From: Mike Turner [REDACTED]
Sent: 12 December 2017 20:29
To: Michael Eastham
Subject: Planning Application AL/123/17/PL - Mildmay, Hook Lane

I am a resident in Hook Lane and I am writing to you to object to the above Planning Application, AL/123/17/PL.

PROPOSED SOUTH ELEVATION

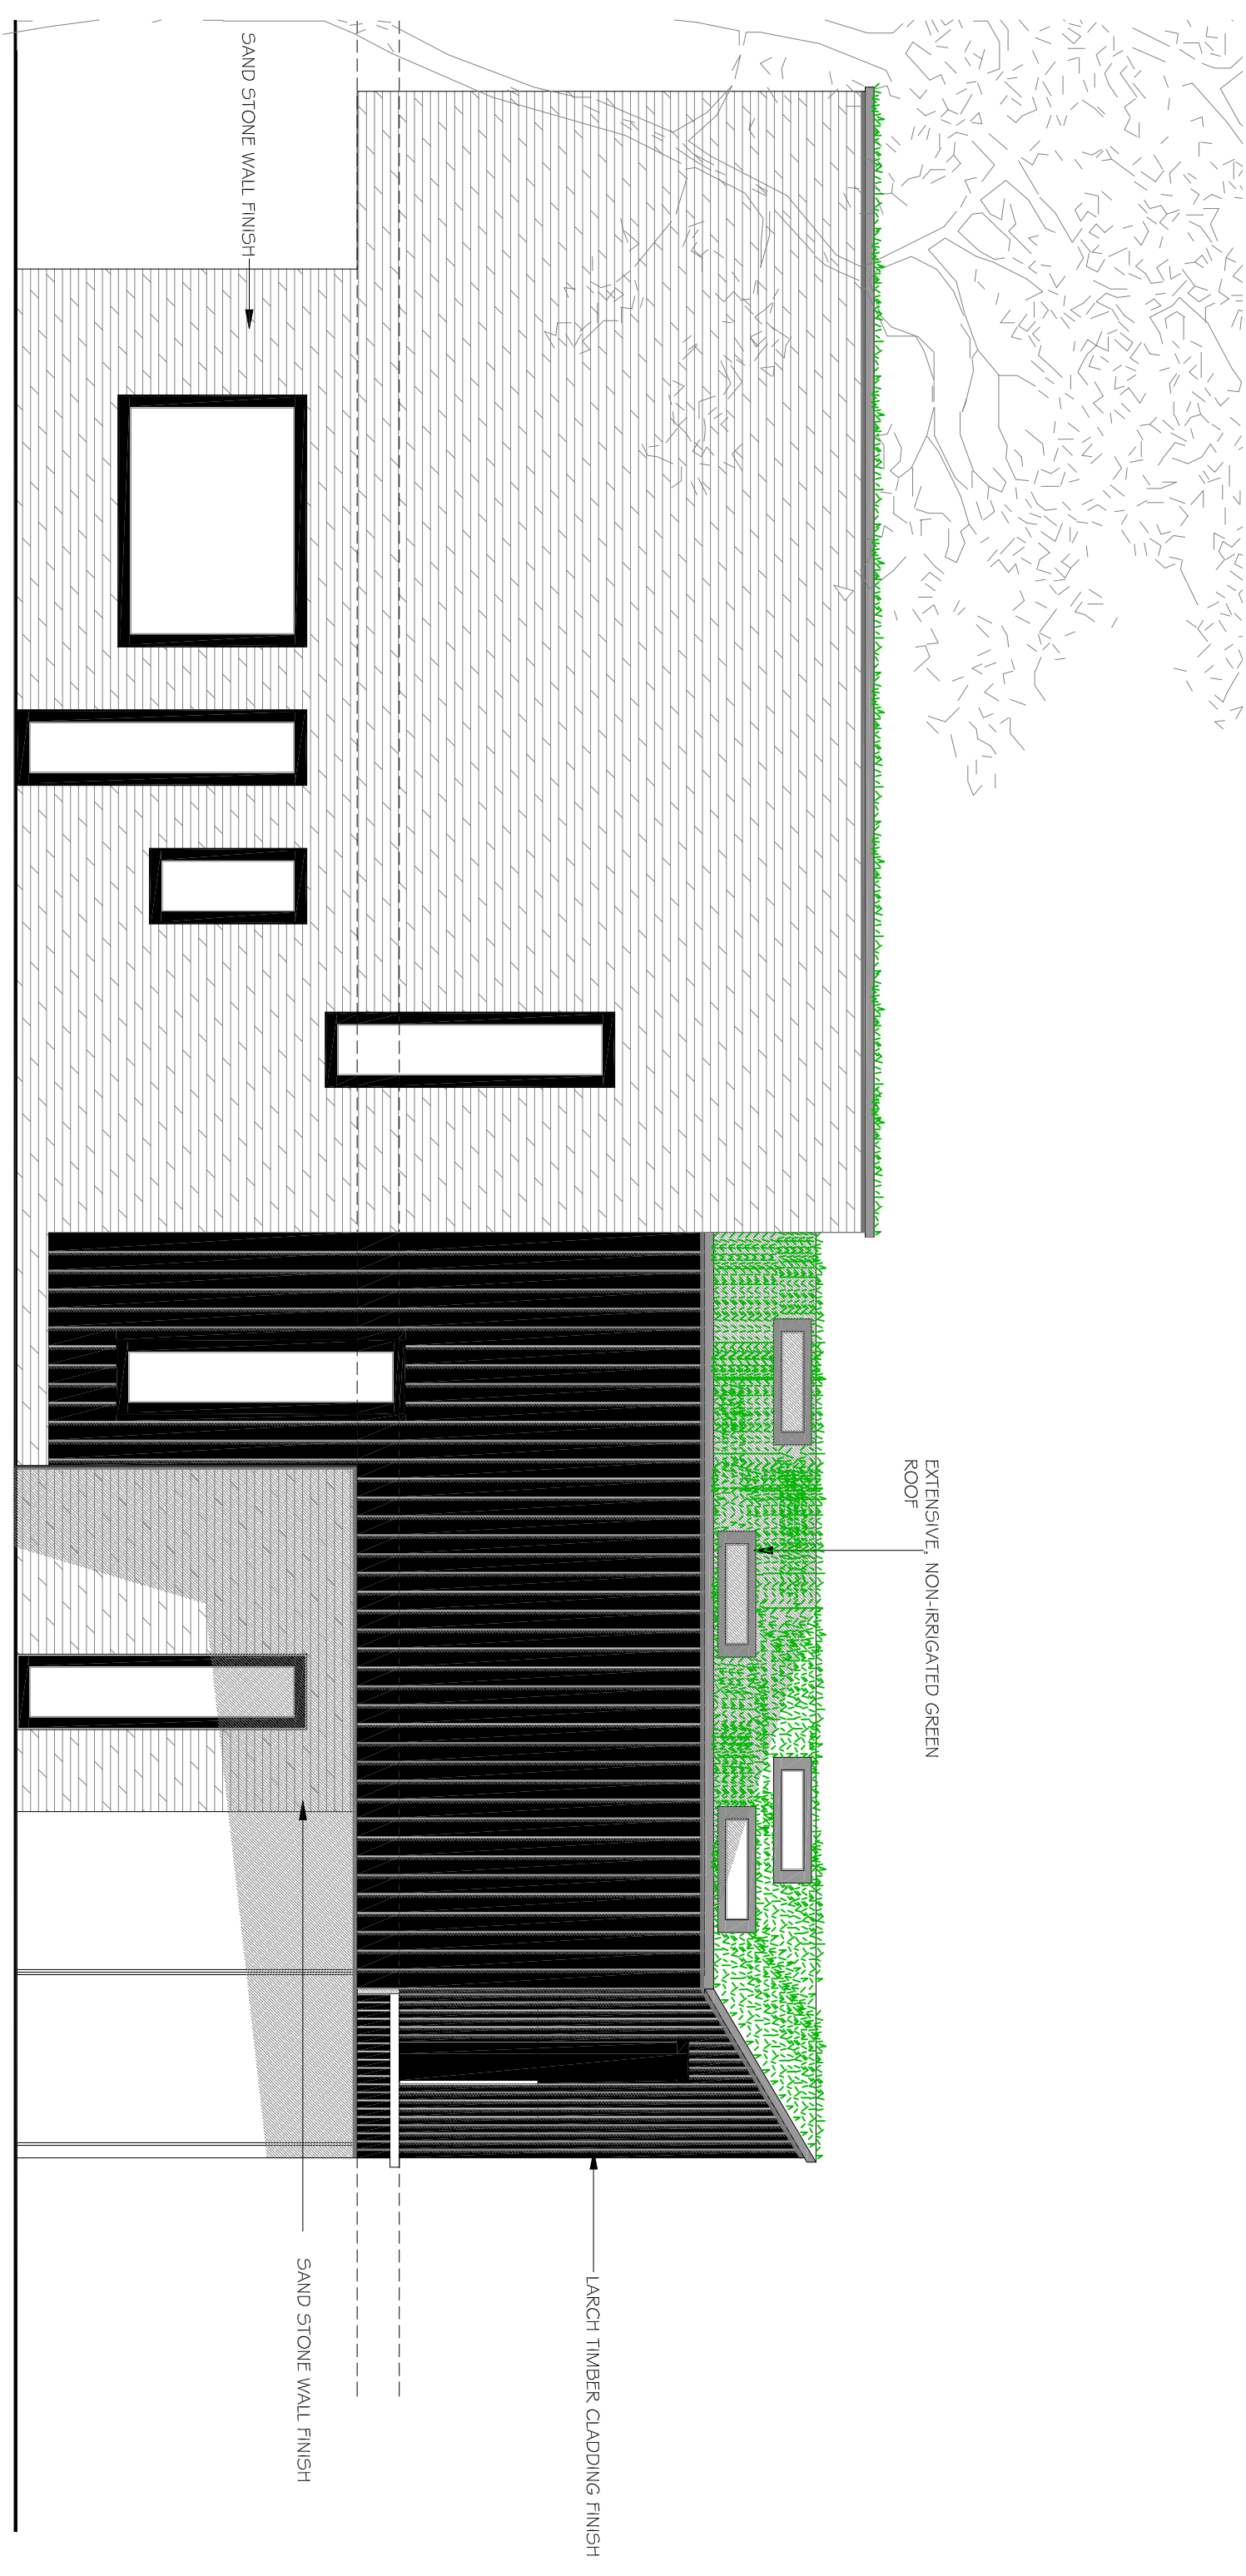
I further believe that it is wrong to allow a 2-storey dwelling to be constructed on the site of an existing single storey building which is so over-bearing to the next door single storey property called "The Nook". It is to the south of "The Nook" and therefore will cast a strong shadow most of the day onto this property and take a huge amount of the light that is presently enjoyed by "The Nook" away permanently.

A more conventional one and a half storey chalet type design would be far less intrusive and light blocking provided it was designed with care so as not to shield too much sunlight from the South. A conventional front gable design (similar to the other neighbouring house) would certainly take less southern light away from "The Nook" than the proposed block design.

DRAWING TITLE:
PROPOSED STREET SCENE

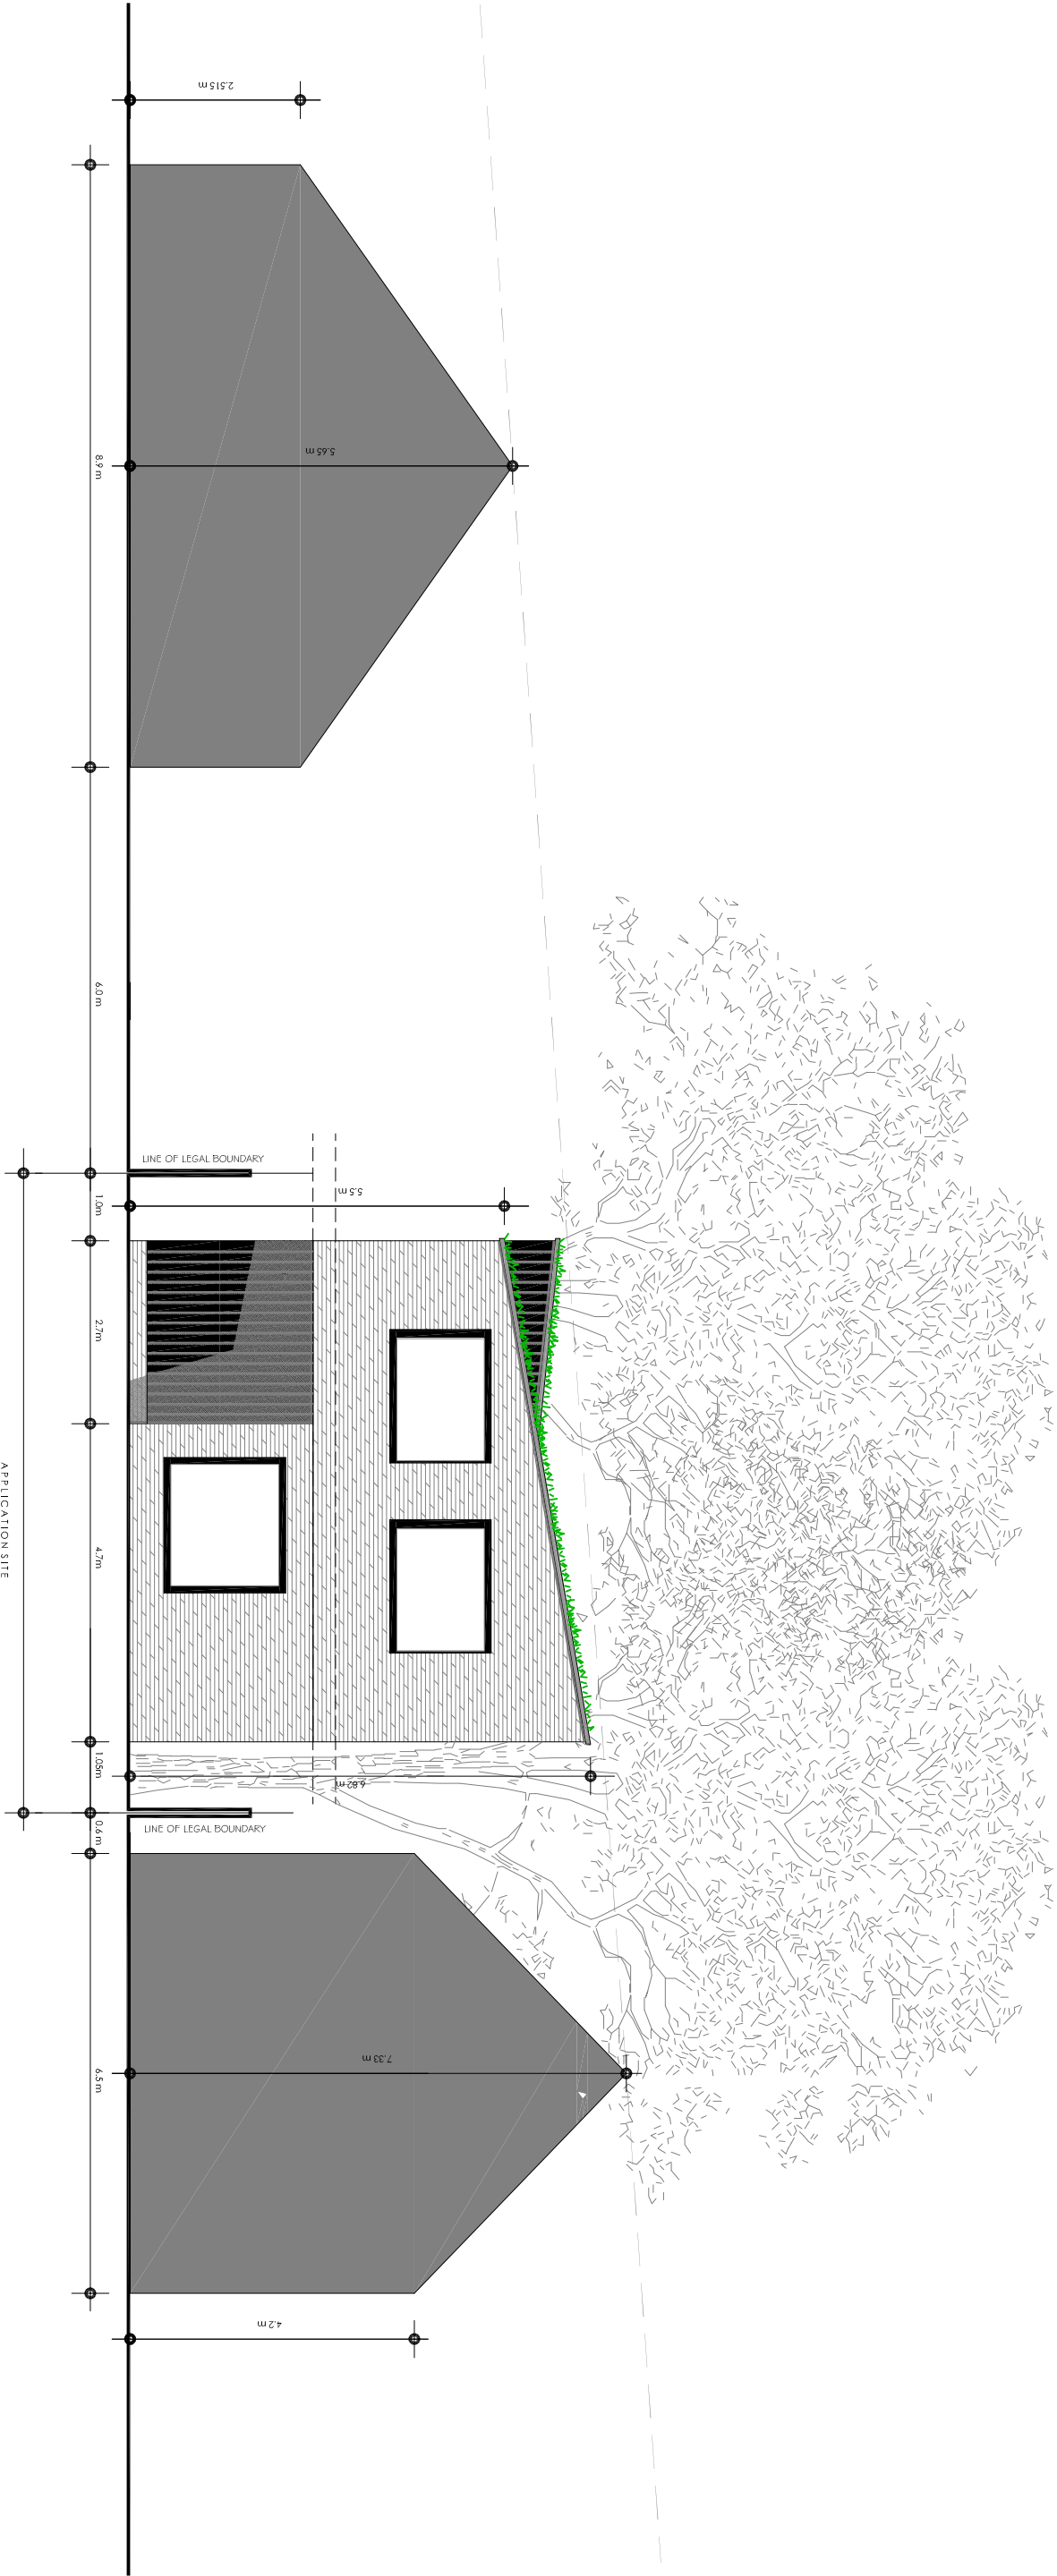
1. The design appearance of the proposed new dwelling is completely out of character with all of the existing houses in Hook Lane and directly goes against Aldingbourne NDP Policy H2 - Quality of Design, which states that :-
